Subject: New comments for application 19/01705/OUT

New comments have been received for application 19/01705/OUT at site address: Land Adjoining And West Of Bloxham Recreation Ground South Newington Road Bloxham

Objection

Figure 5.1: Development Framework Plan.

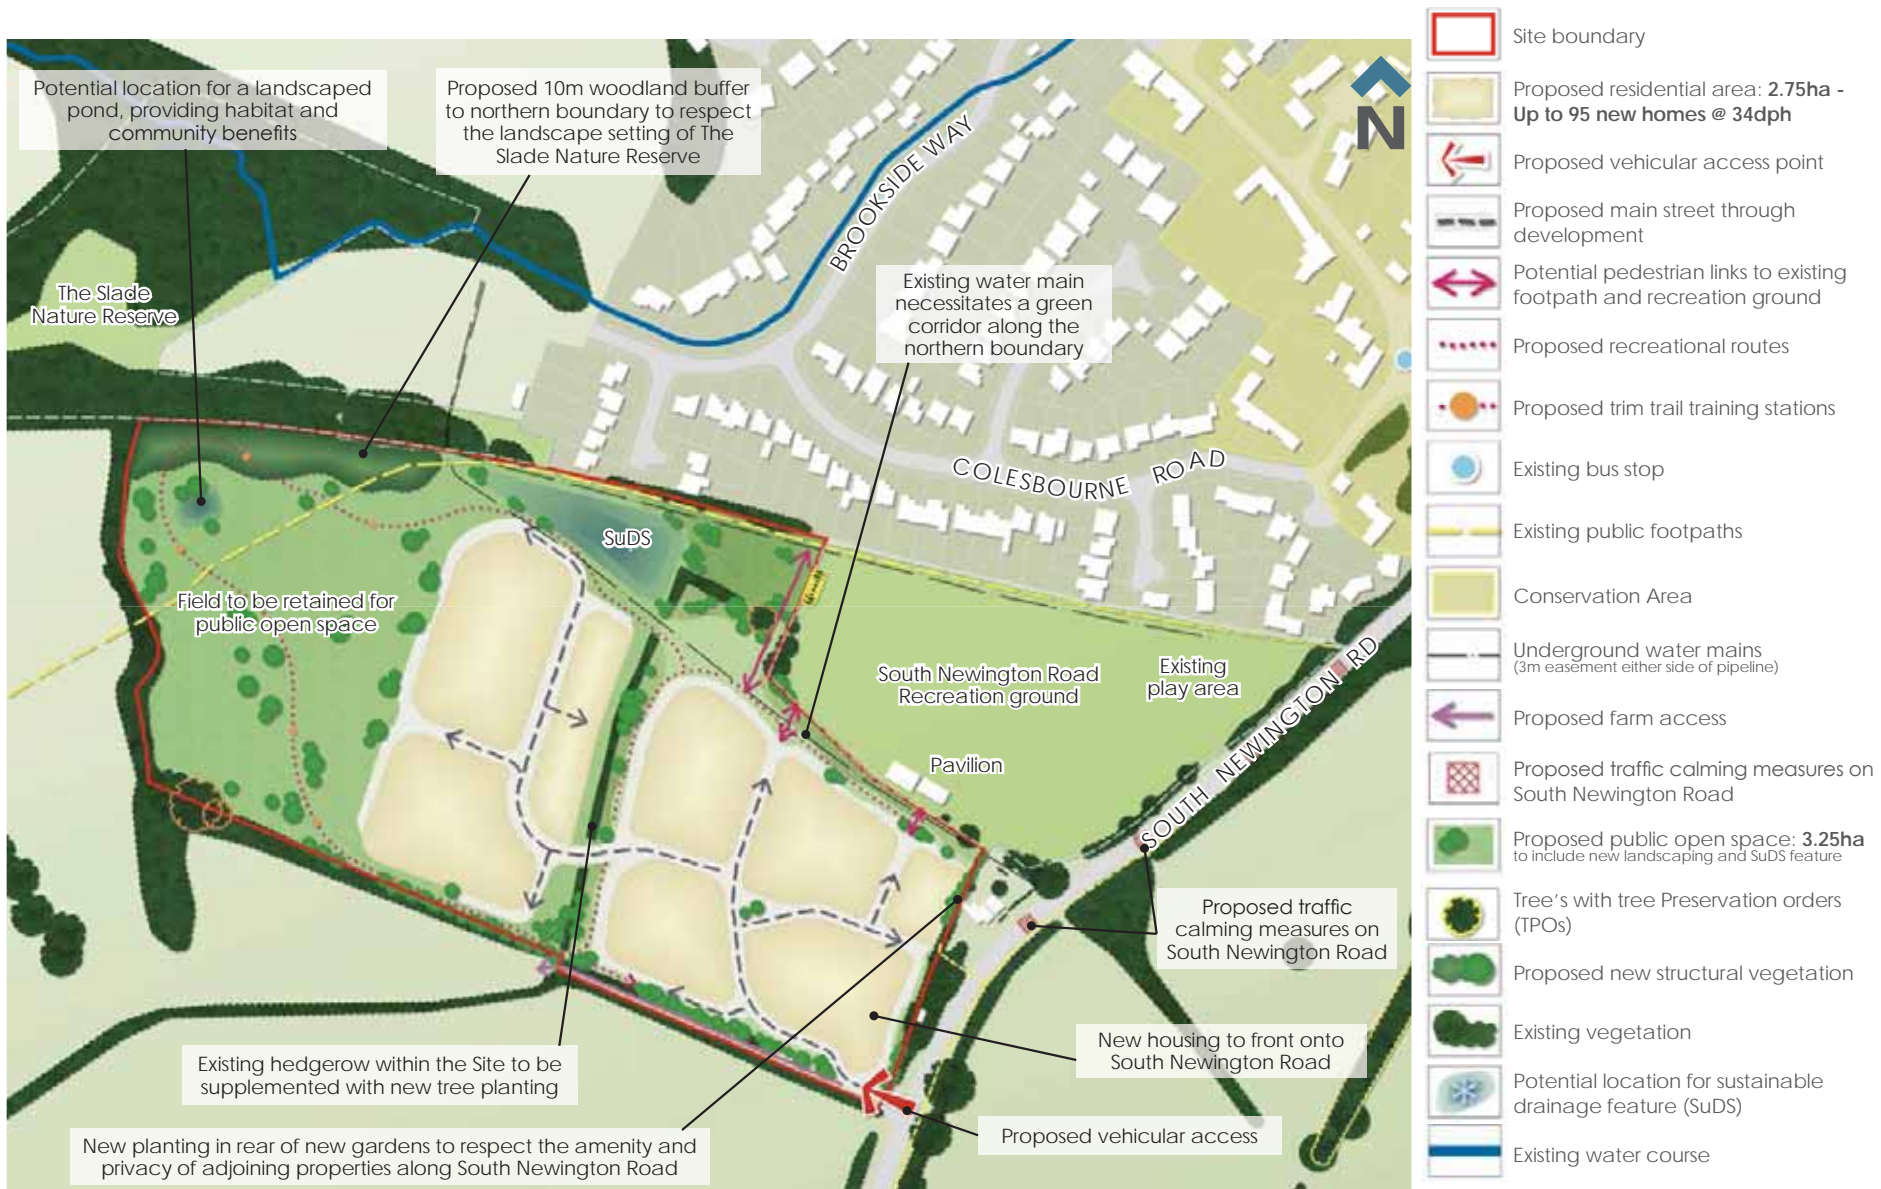
The site plan shows the SuDS as though it is a sort of 'pond' in one corner of the site, but as Thames Water explains, a SuDS is a system of permeable surfaces feeding into underground structures. It doesn't seem possible for that system to be applied to Gladman's site when the roads and pavements are so far from the area labelled 'SuDS'. Is Thames Water fully aware of the proposed SuDS plan?
